# PORTLAND MAINE

March 24, 2009

RE: 8 Ryefield Street, Peaks Island – 084 E005 – IR-2 – illegal deck & tent shed – permit #08-1580

RYEFIELD STREET

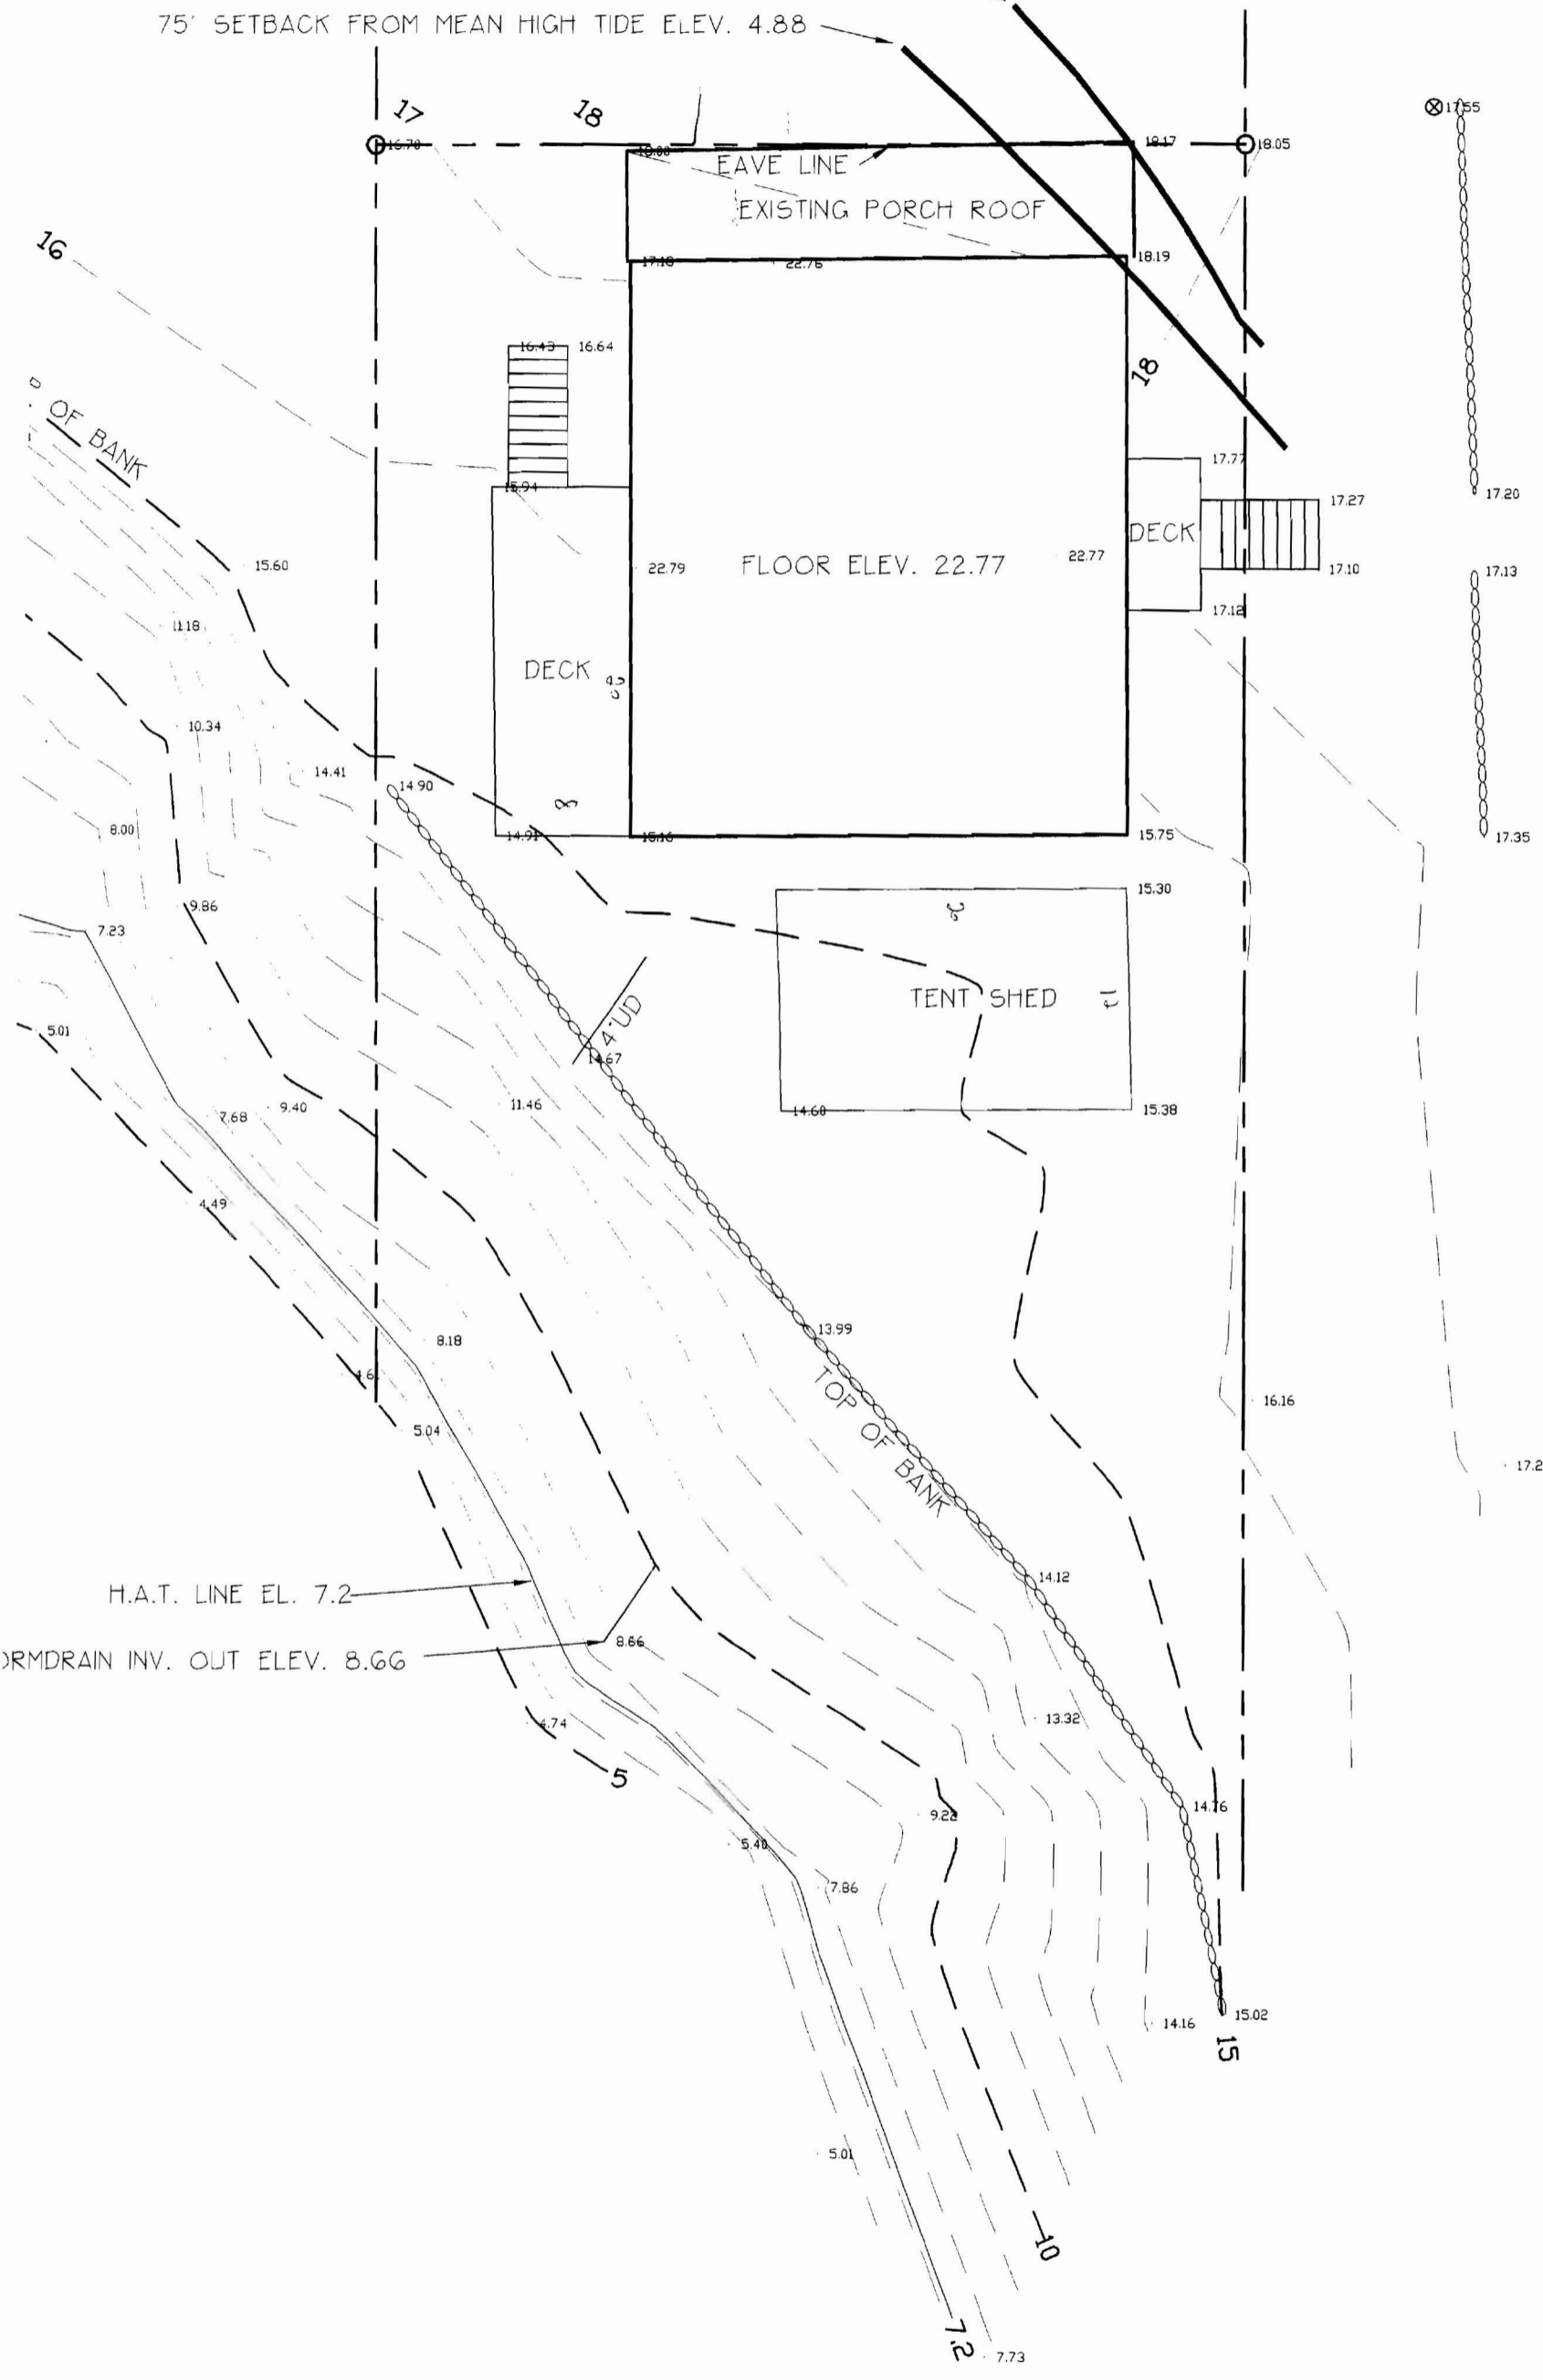
The property is located in the IR-2 zone. Section 14-145.11(c)(2) gives the minimum rear setback as twenty-five feet. The rear setback to the deck is about eight feet, and the rear setback to the tent shed is twenty-three feet. Section 14-145.11(c)(3) gives the minimum side setback as twenty feet. The stairs from the deck are eleven and a half feet from the side property line. Section 14-145.11(d) gives the maximum lot coverage as twenty percent. Since the lot is 3,393 square feet, the allowable lot coverage is 678.6 square feet. The footprint of the existing structure is 1,151 square feet, so it is already over the allowable lot coverage.

The property is also located in the Shoreland Zone. Section 14-449(a) states that all principal and accessory structures must be setback at least seventy-five feet from the high water line. Both the deck and tent shed are located within the seventy-five foot setback from the high water line.

# RYEFIELD STREET

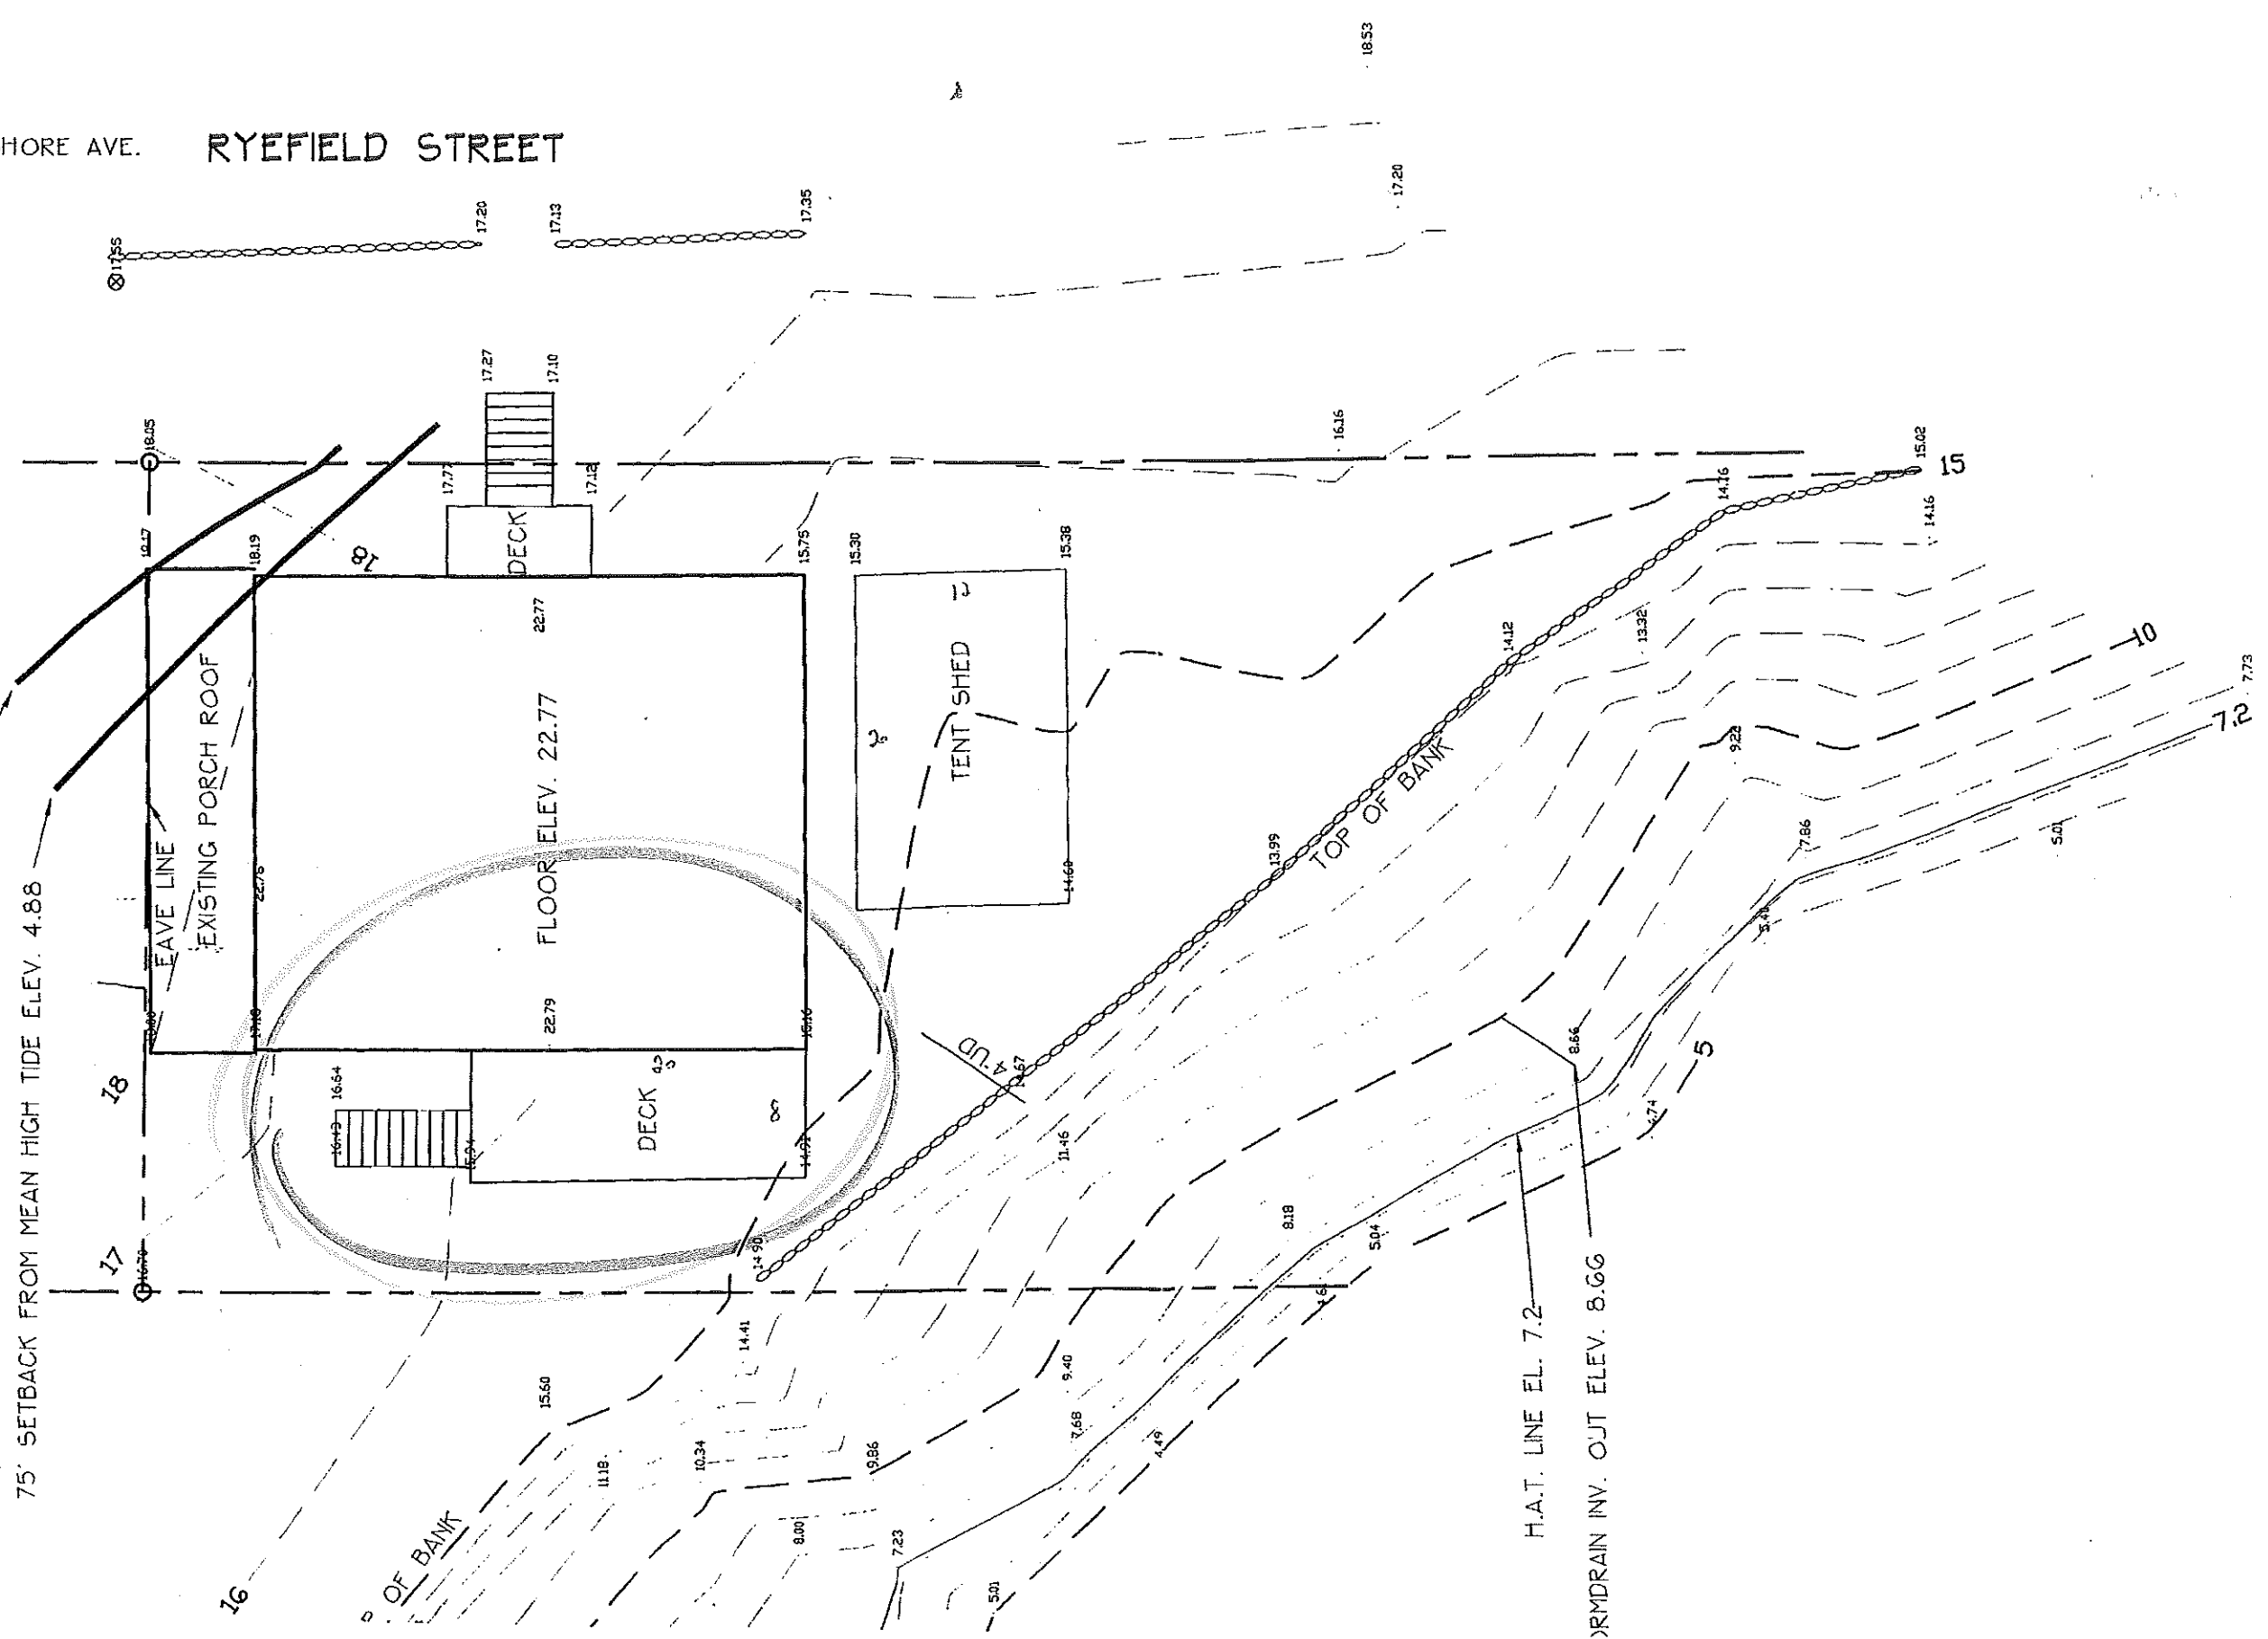
In my review of your permit application (#08-1580), it came to my attention that the eight by twenty foot deck and stairs off the rear of the building were never permitted. The twelve by twenty foot tent shed also was not permitted. If we cannot find a permit for the deck or tent shed, we use the footprint shown on the pre-1957 assessor's card to determine what the legal footprint was in 1957 when the ordinance went into effect. Neither the deck nor the tent shed were shown on the pre-1957 assessor's card. Since they were not permitted and were not shown on the pre-1957 assessor's card, they are not legal and the property must be brought into compliance.

You have thirty days from the date of this letter to bring your property into compliance. Since the deck and tent shed do not meet the required setbacks or the maximum allowable lot coverage, and they are located in the shoreland zone, they cannot be permitted and therefore need to be removed.
